Application for a Non-Material Amendment Following a Grant of Planning Permission

2 Top Road

DC/23/2090/FUL

Proposed South Elevation
 Scale 1:50

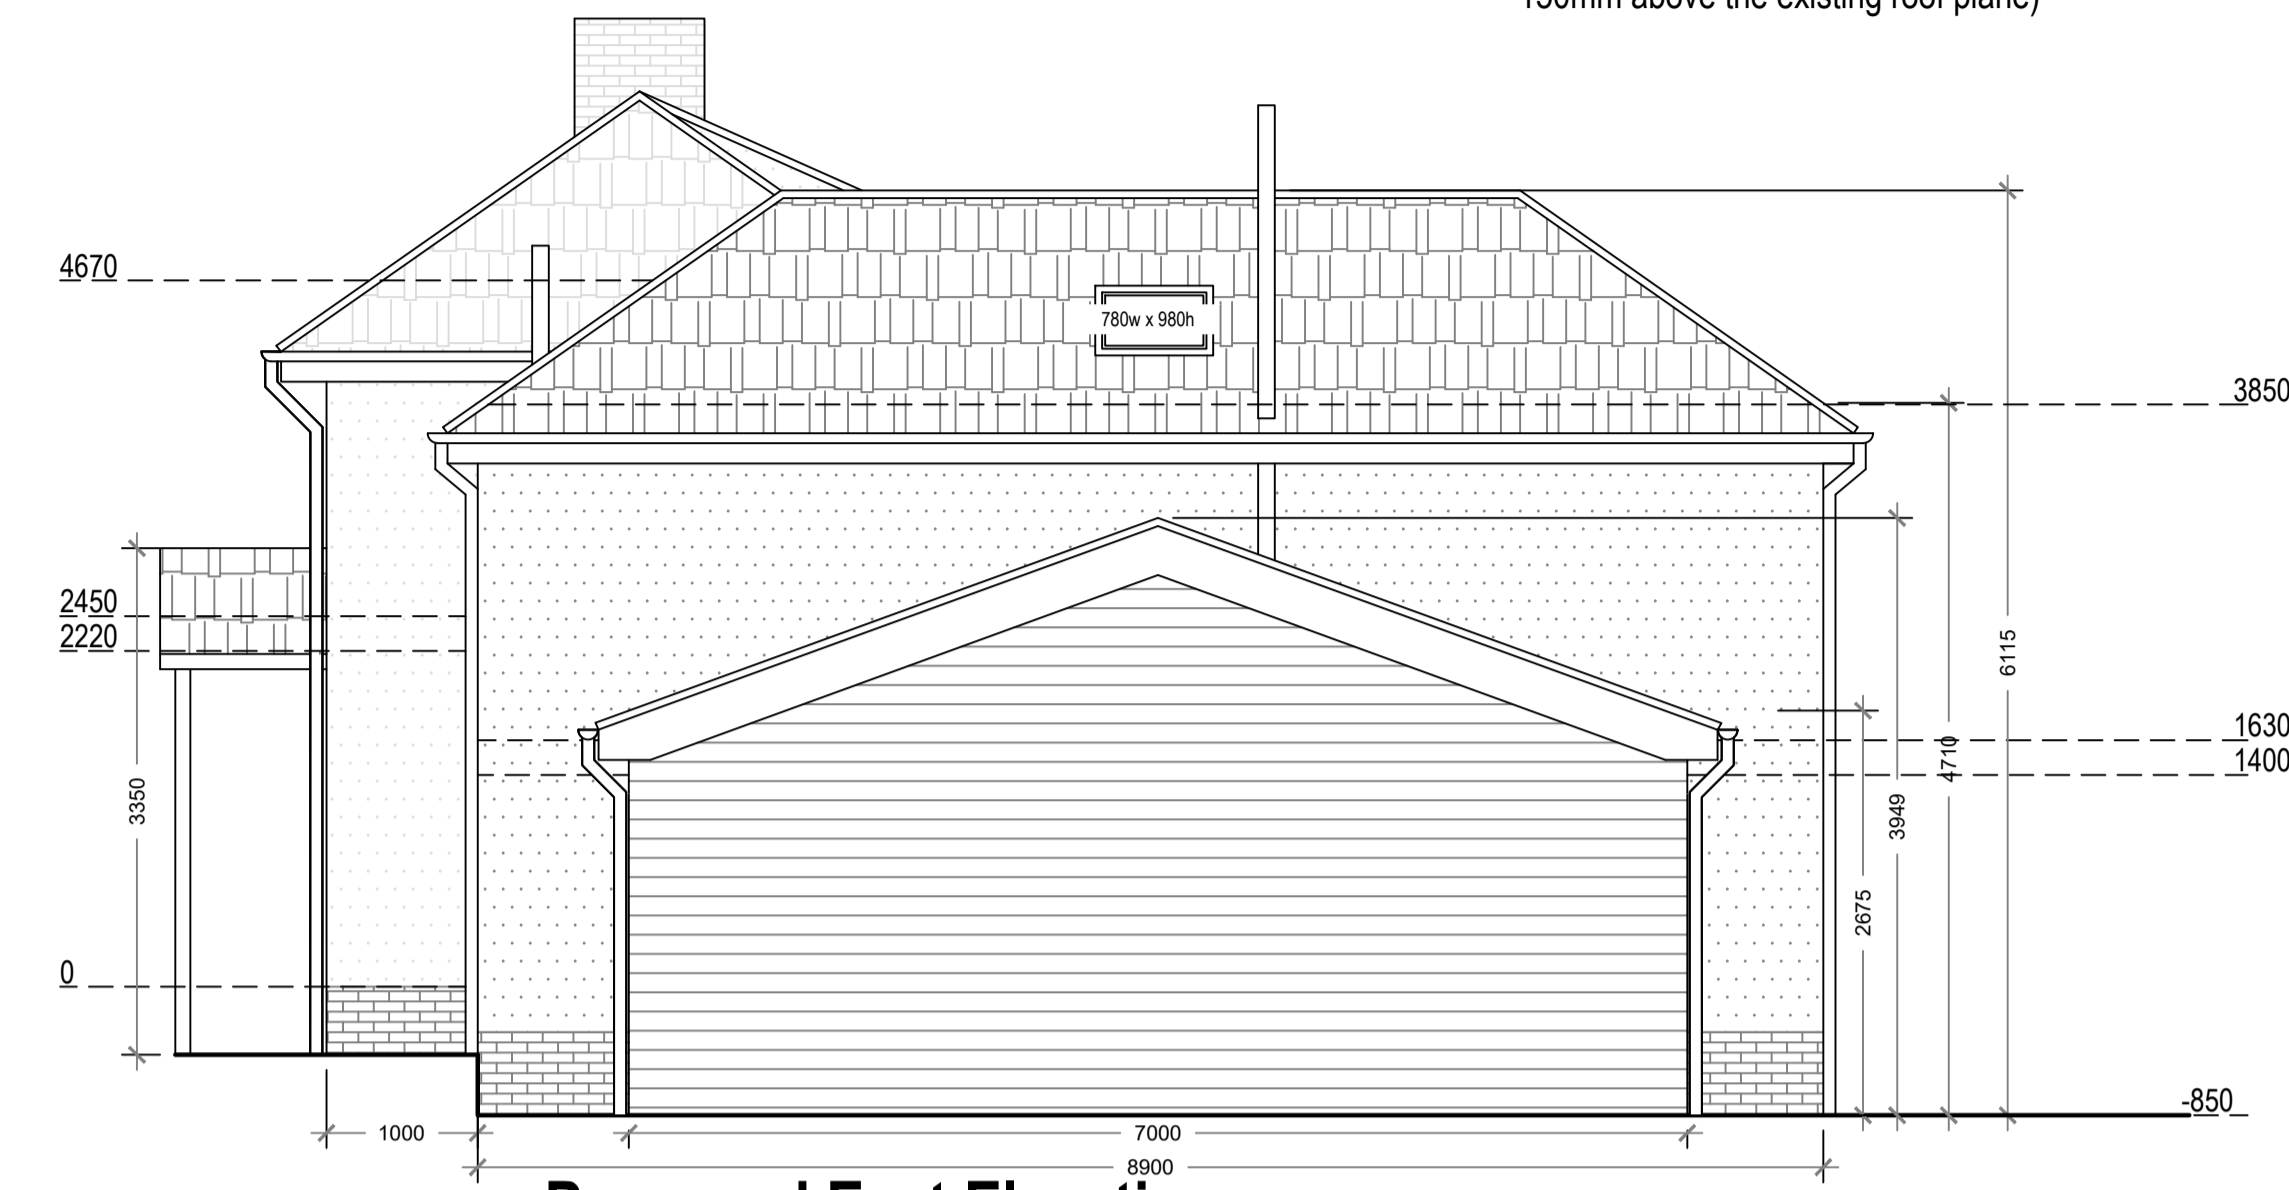
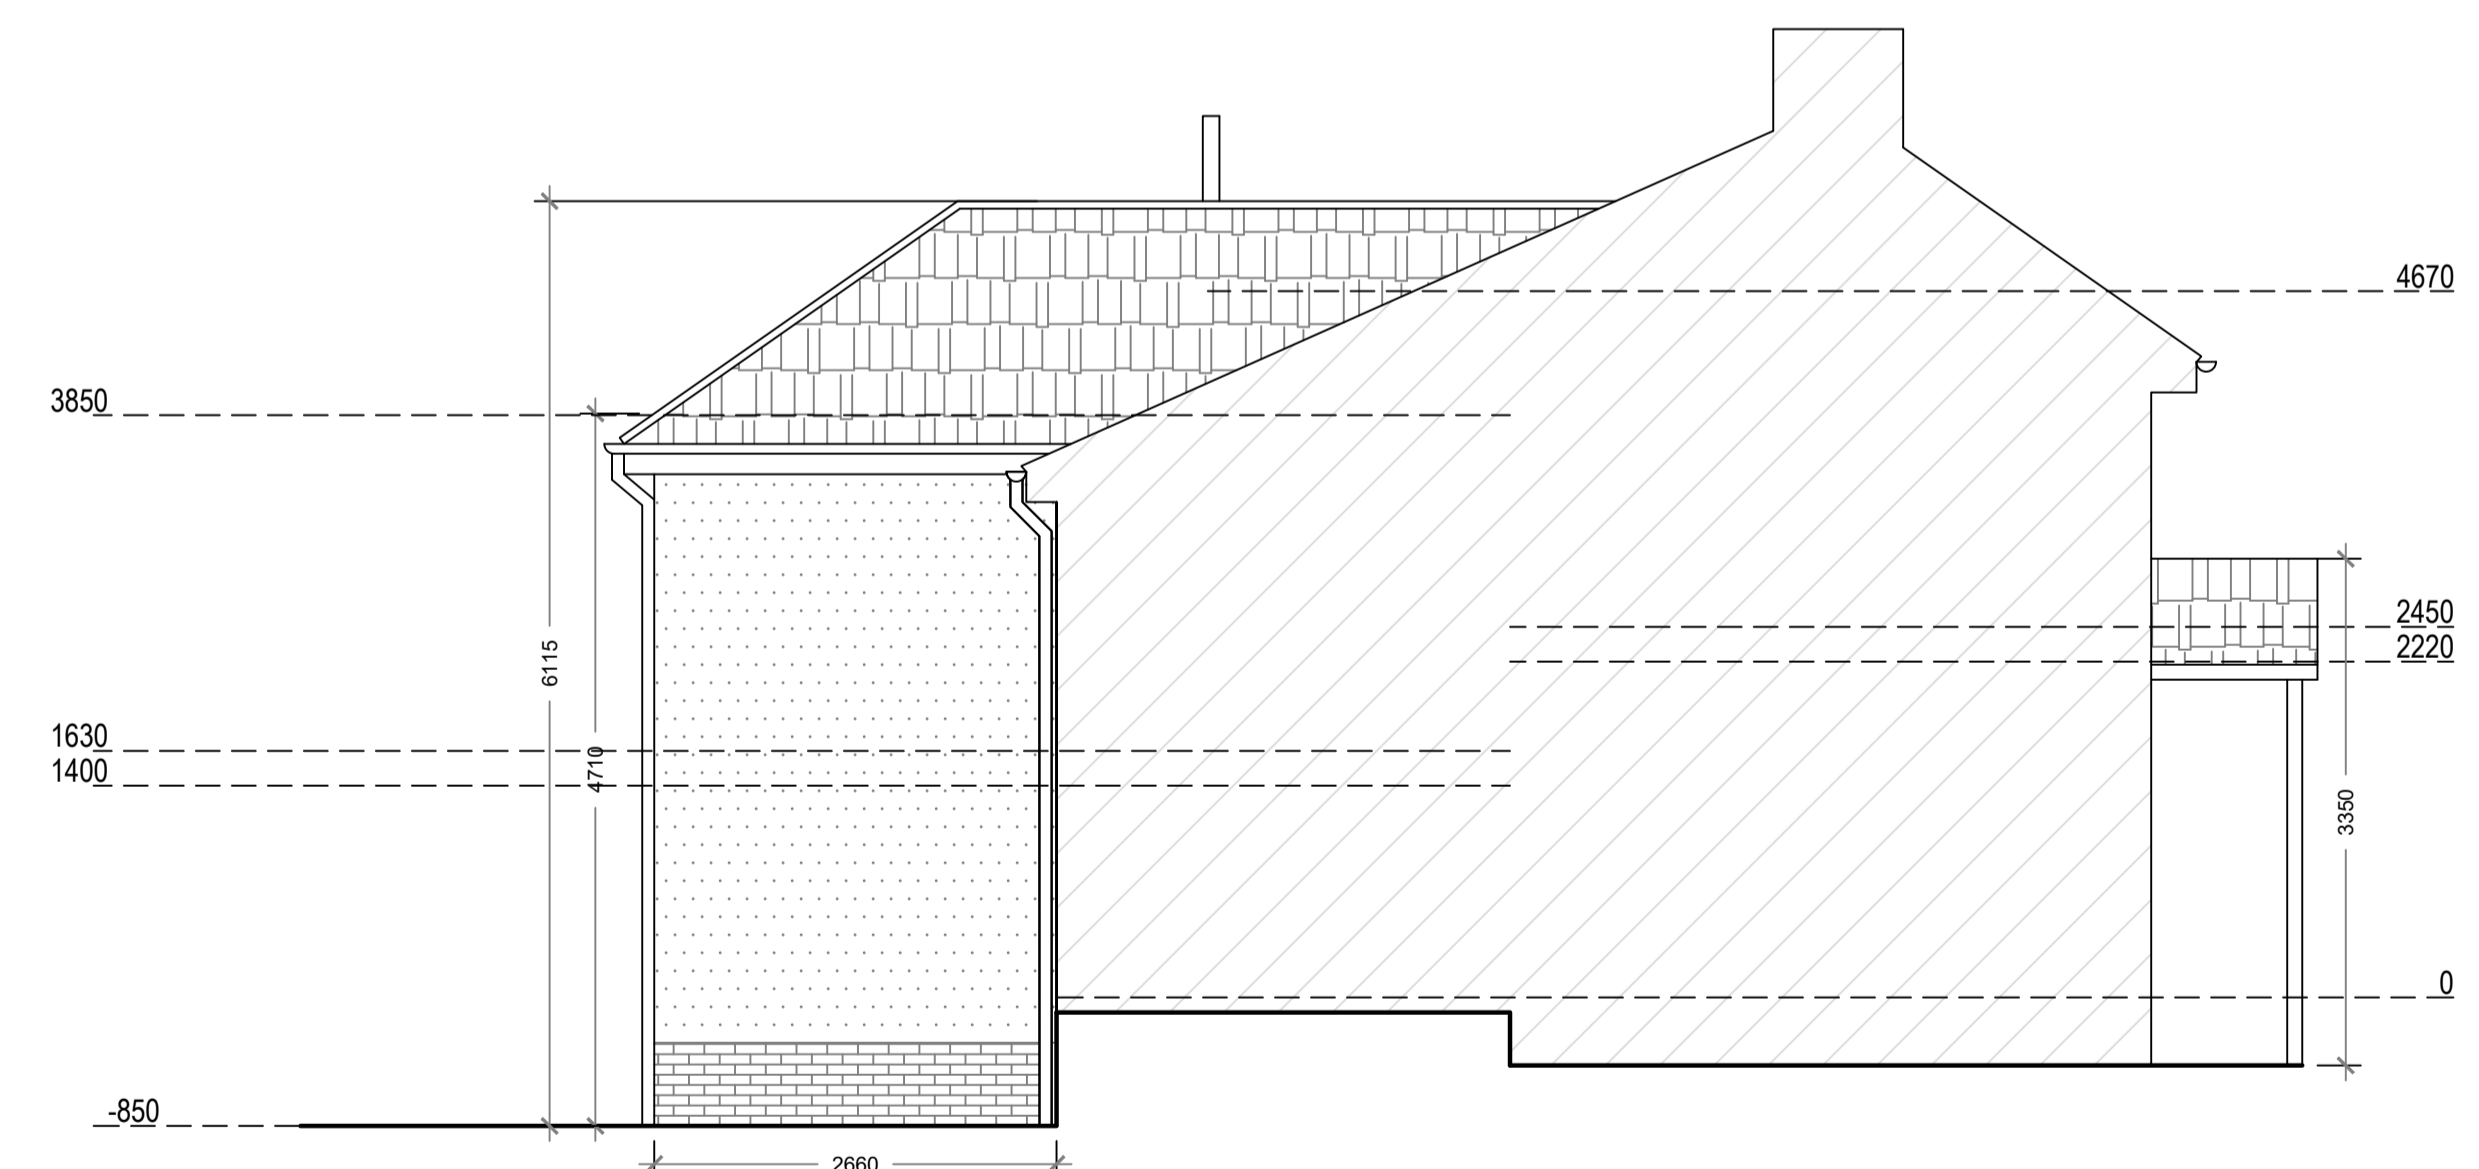
We'd like to propose changing the front elevation finish, of the extension only, to a red brick rather than a render finish so that it is in keeping with the original workshop which stood on the site and also in keeping with the finish on the attached neighbouring cottage.

We feel that having a matching render finish on the new extension section will affect the symmetry of the existing semi-detached cottages, and with us making the extension subservient to the existing cottages, having a brick finish which ties in with what was there before (and what has been used on the attached neighbouring cottage) would be more appropriate.

As there is already faced brick shown on the plans its addition should not be resisted. If you get any problems let me know.
